Date: 7 November 2019

Our Ref: 2019/563844

File No: R/2016/35/B and D/2016/36/B

**Barangaroo Buildings R4A and R4B – SSD 6964 and SSD 6965 Mod 1 –
R/2016/35/B and R/2016/36/B**

West Elevation

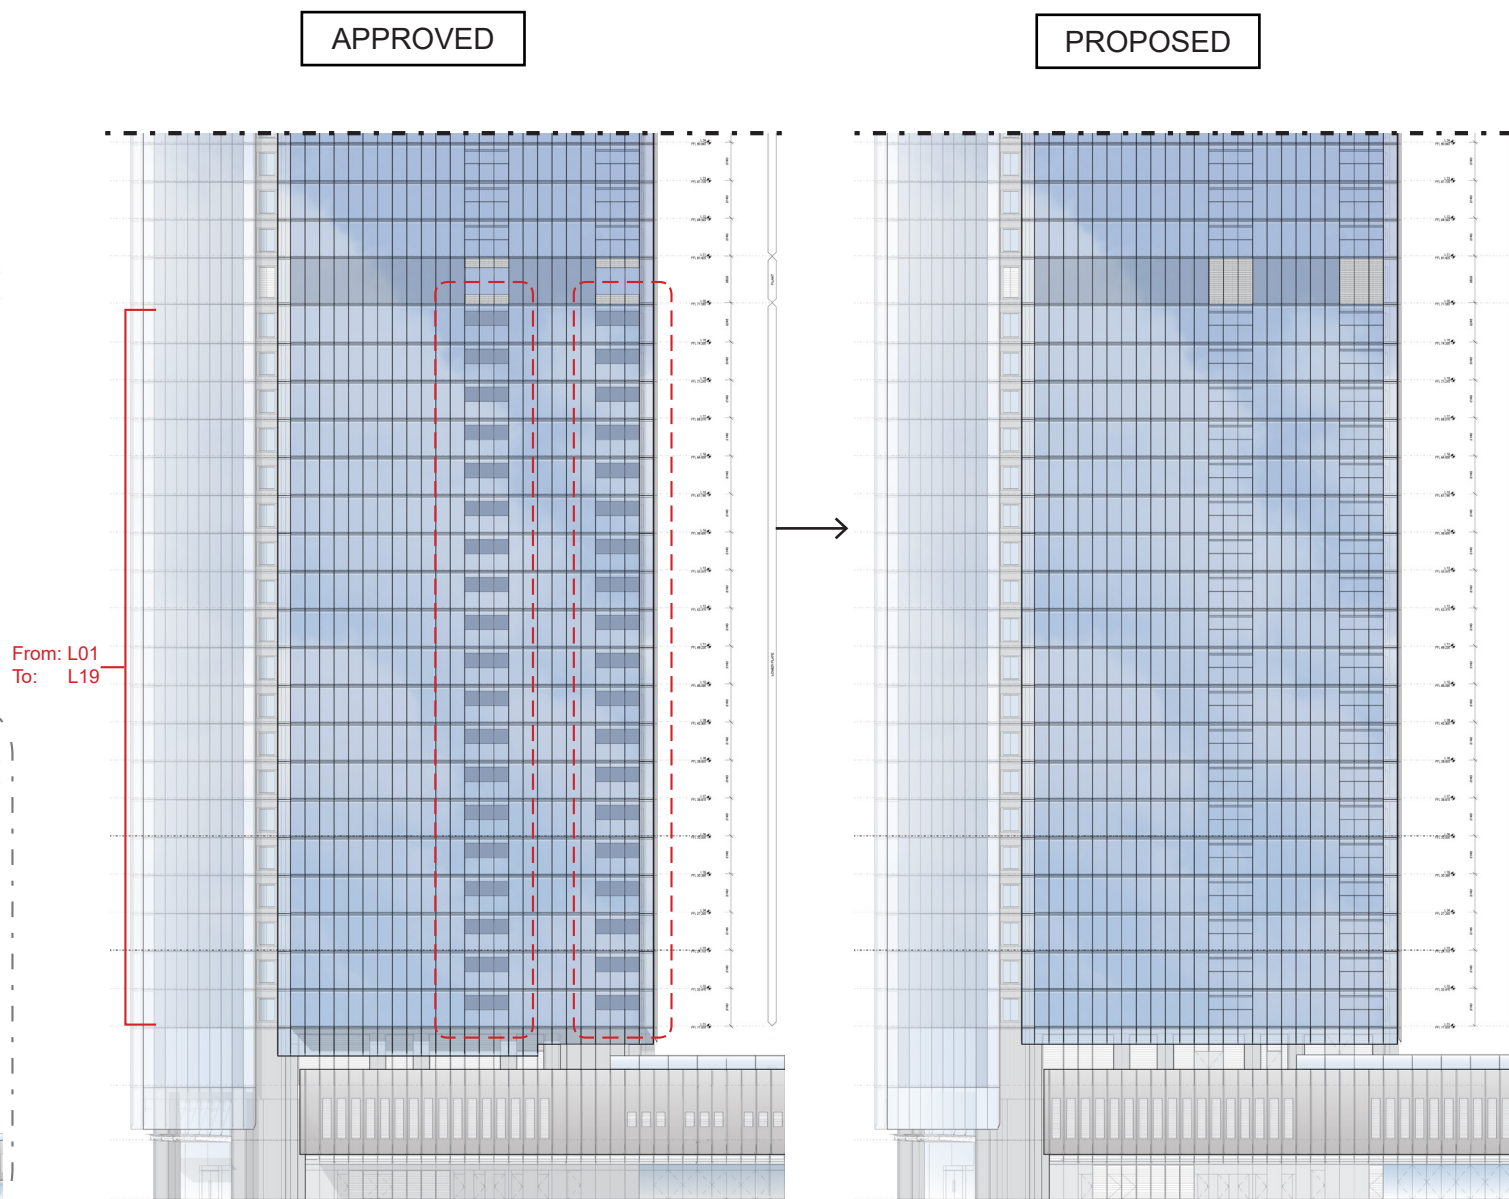
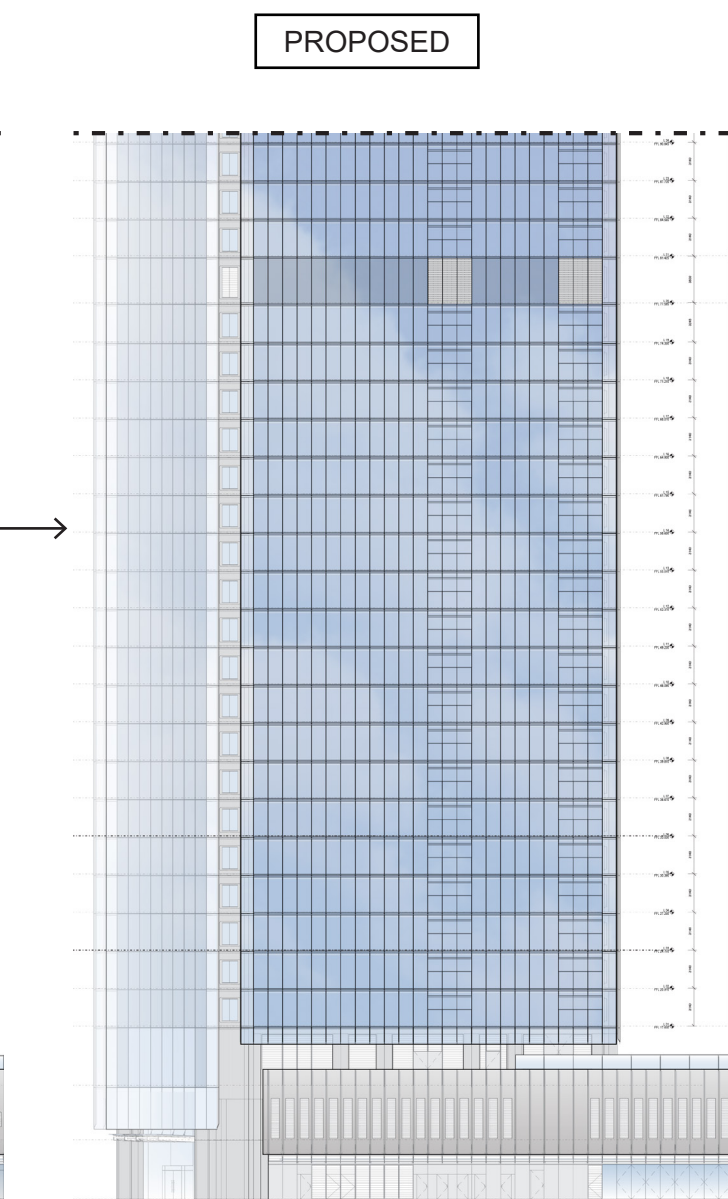
The City's planning controls include provisions for winter gardens to dwellings considered "wind affected", that is, where the dwellings are located 30 metres above ground level – see Clause 4.5A of the Sydney Local Environmental Plan 2012. The application states that the balconies located at levels 1-19 will also be wind affected, however, this is not verified by a wind report.

The City requests that winter balconies are only permitted in accordance with this standard, in particular:

- (a) the balconies below the 30 metre threshold remain permanently open;
